From: **Ashwin Muralidharan** Date: **30 Jul. 19** File No: S25504\148\H-121\ca190730s0017 Pages: 2
Project: **Qantas Flight Training & Simulator Centre (Tender No. 9760)** No: **H-004[1.0]**

Hydraulics – Response to Comments on SSDA Submission

This Consultant Advice provides NDY's comments to Agency and stakeholder submissions received during the public exhibition of the SSD 10154 for the development of a new flight training centre at 297 King Street, Mascot.

Project: QANTAS FLIGHT TRAINING FACILITY				
Title: PROPOSED WATER SUPPLY ROUTE OVERALL SITE PLAN				
Document Number: SKH-010A				
Project No: S25504-148	Drawn: A.M.	Date: 17/7/19	Scale: NTS	Rev: 1.0

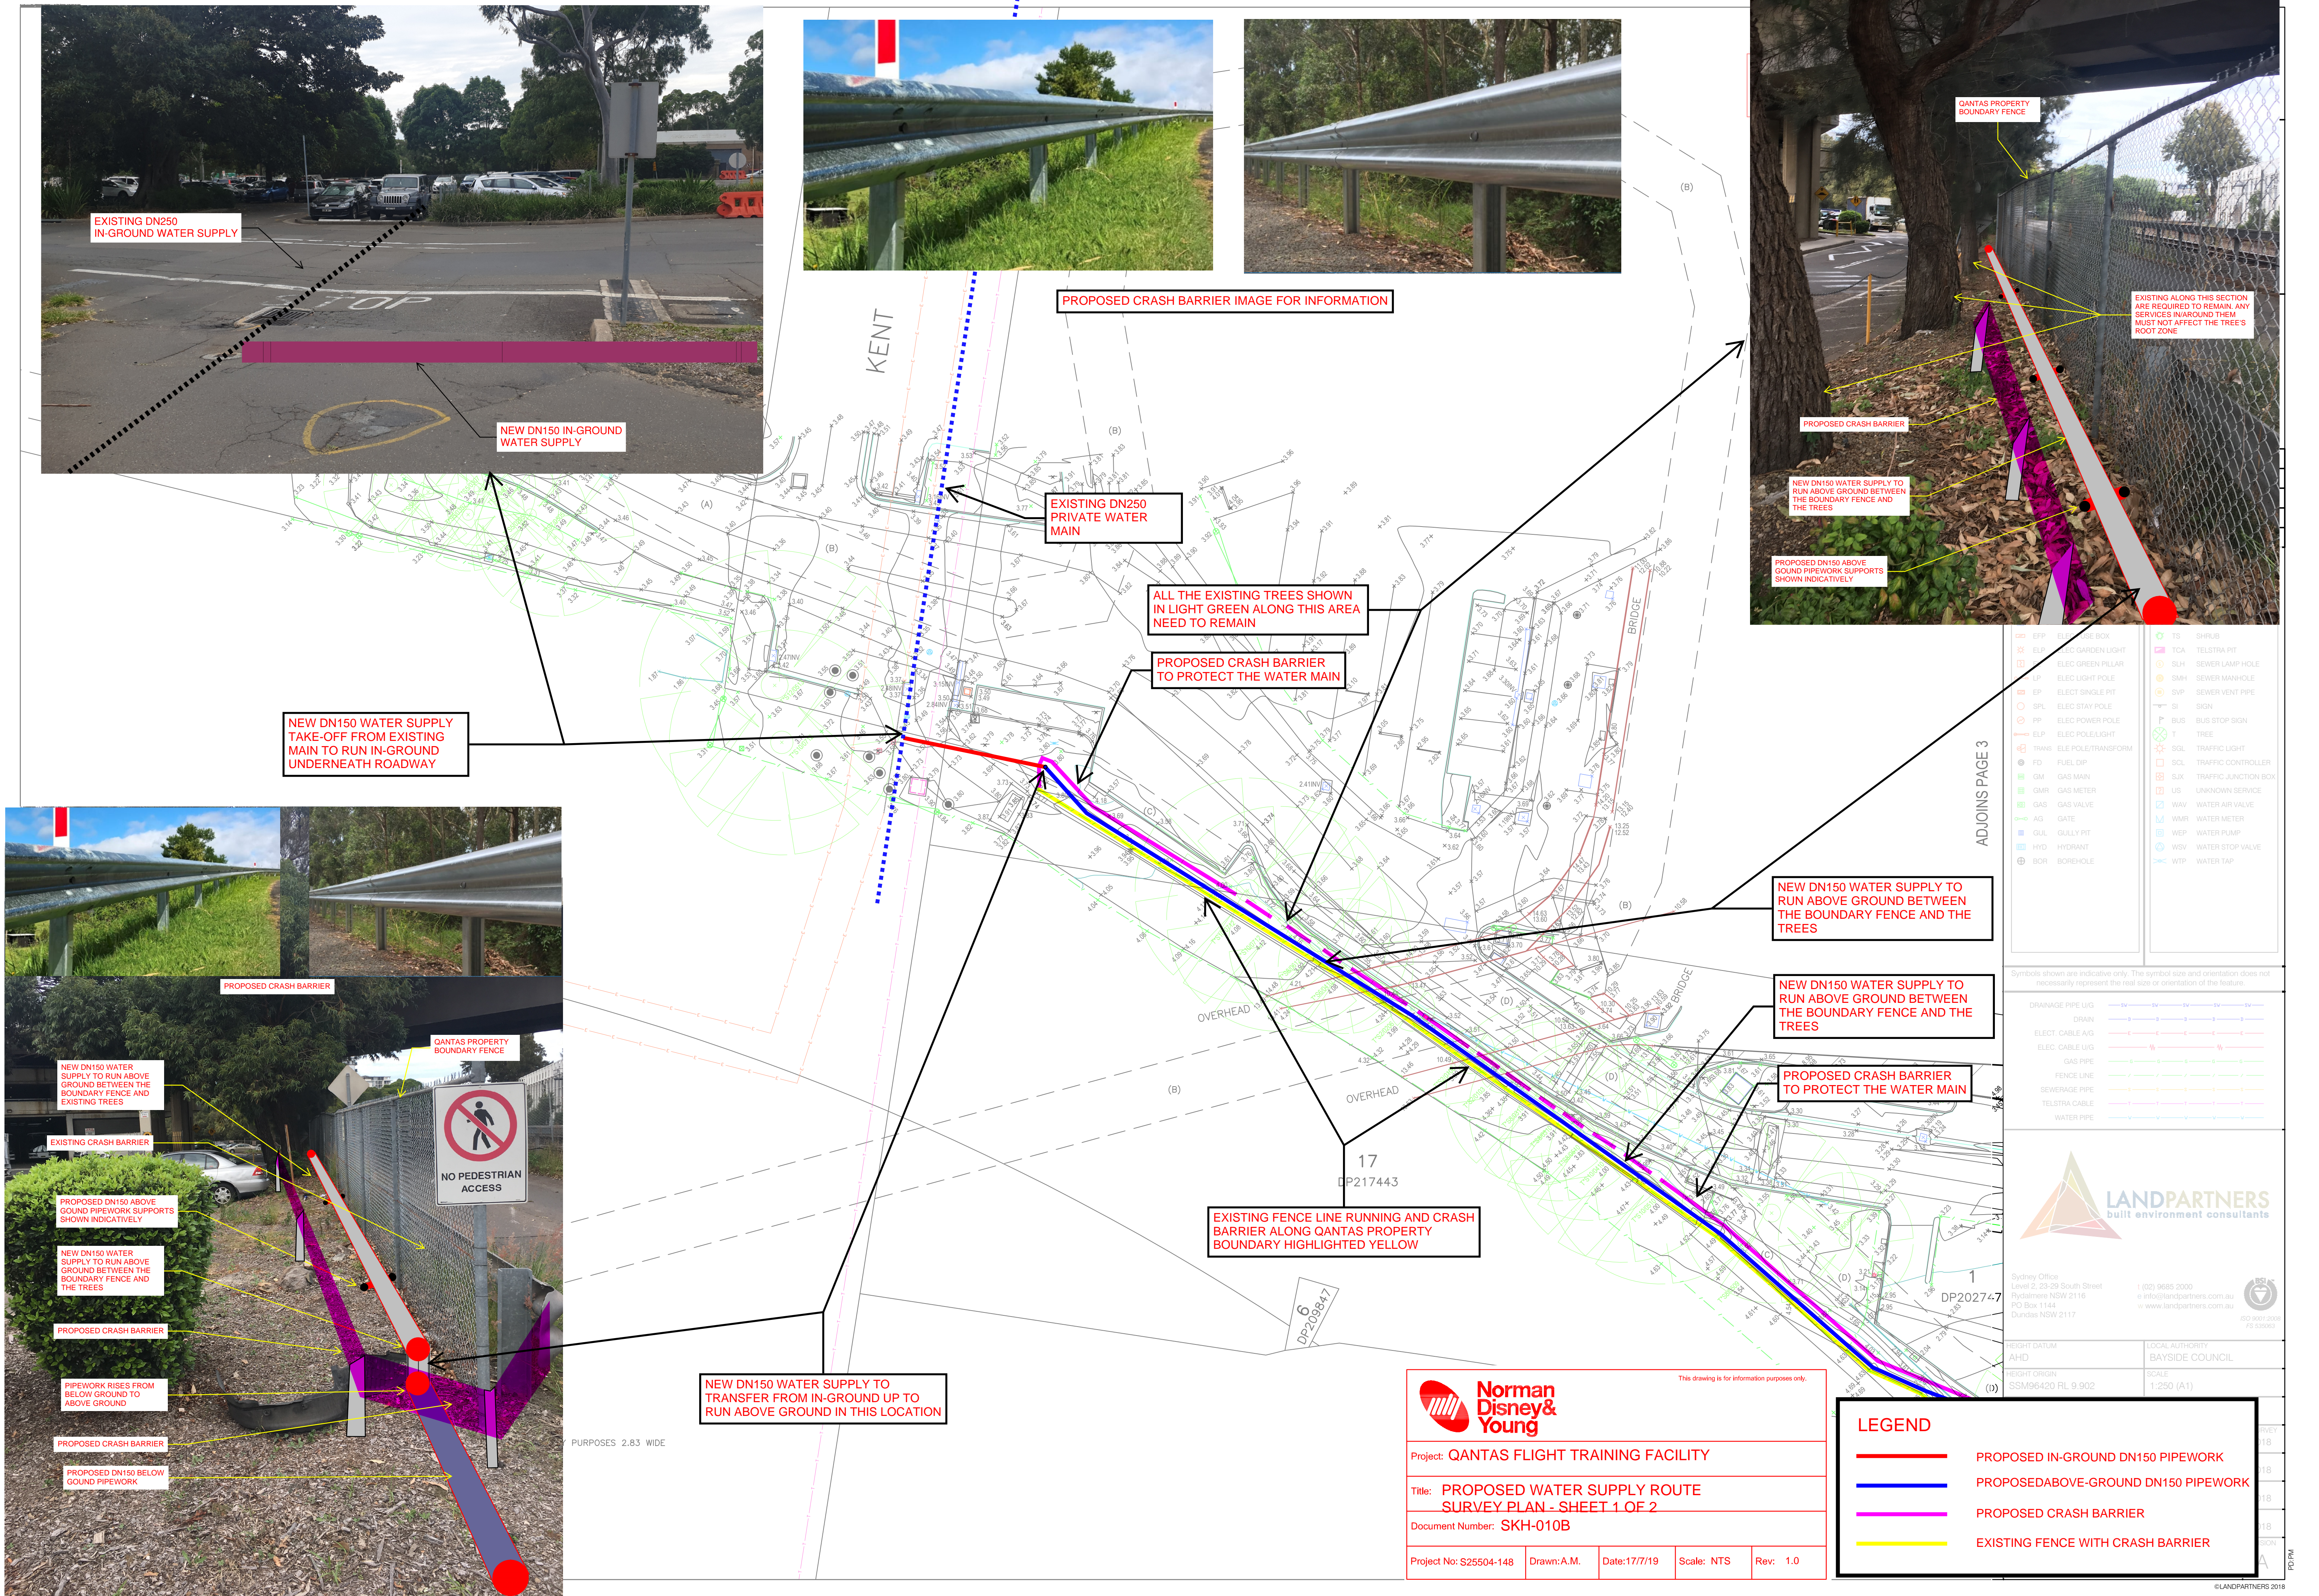
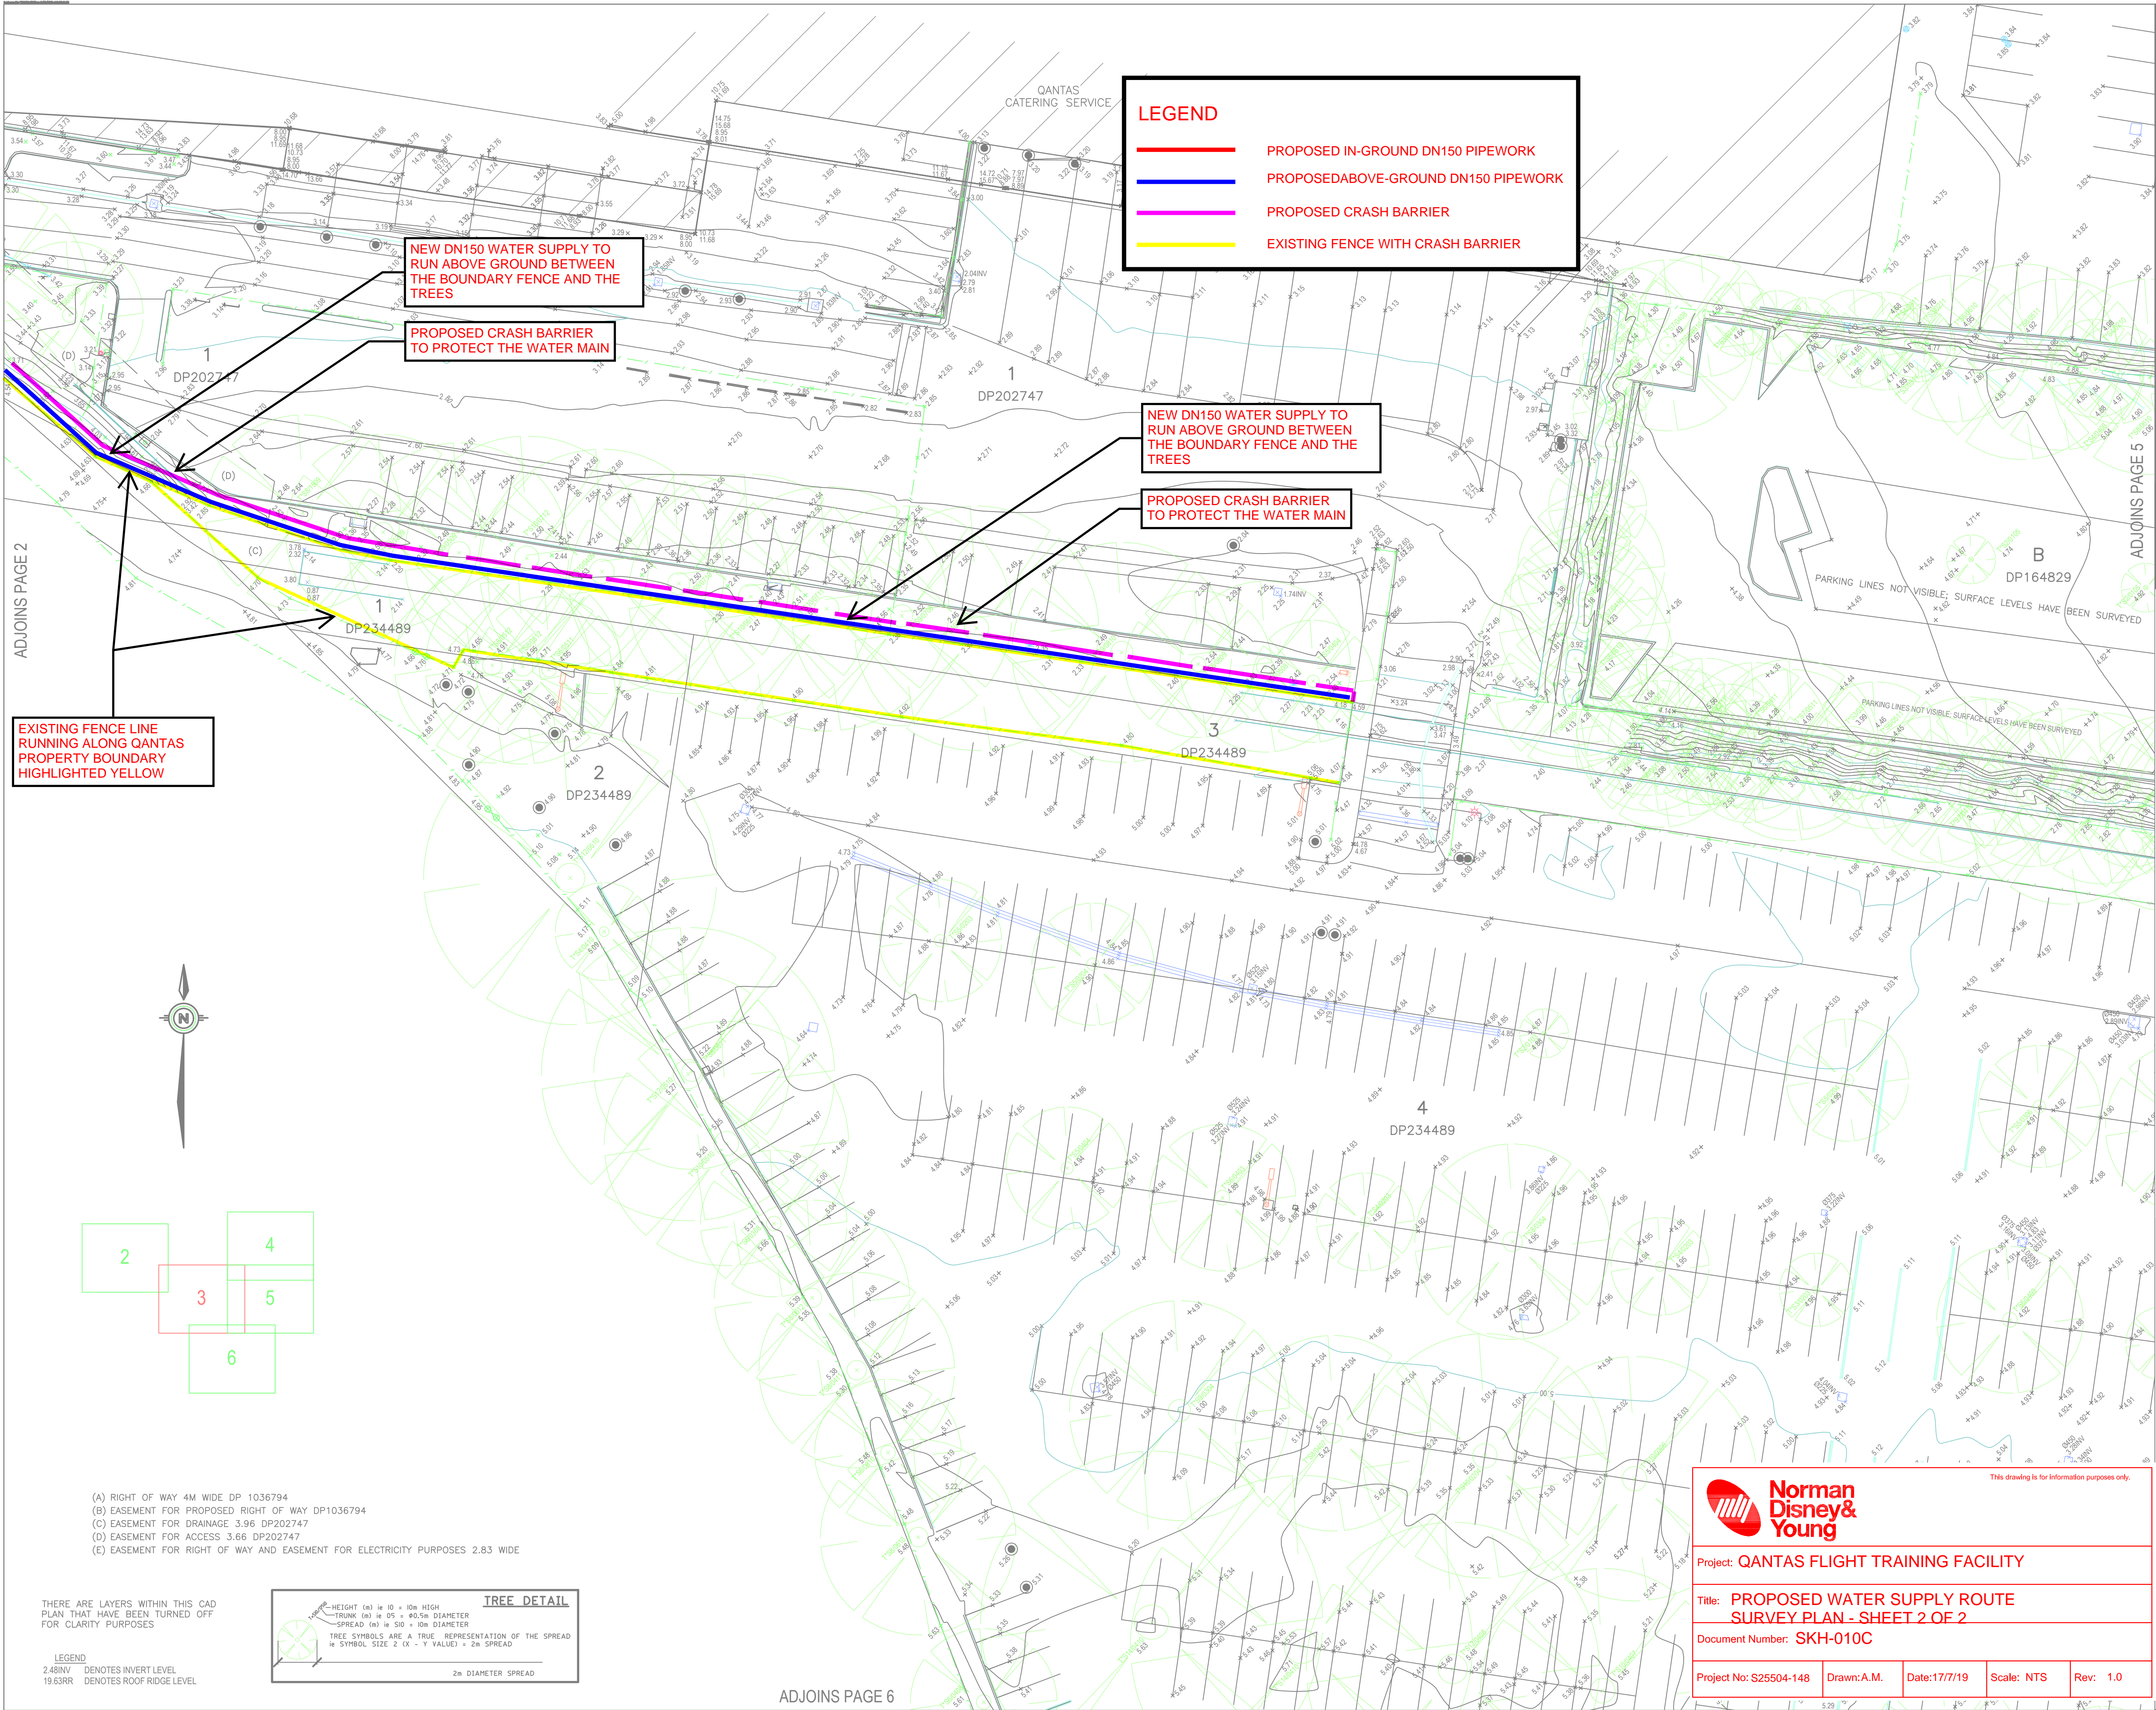
6. Appendix AA – Infrastructure Report Page 4 – Car Park. ARTC does not support the proposed above ground water mains adjacent to the rail corridor as in the event of an incident, the risk to rail safety (including personal and environmental safety) is too significant. Examples of risks include water movement to the rail corridor causing scour and destabilising the formation.

NDY proposal is to protect the above ground pipework using crash barriers. This is detailed within Consultant advice note H-003 [1.0] and includes sketches / pictures of the water main route and crash barrier.
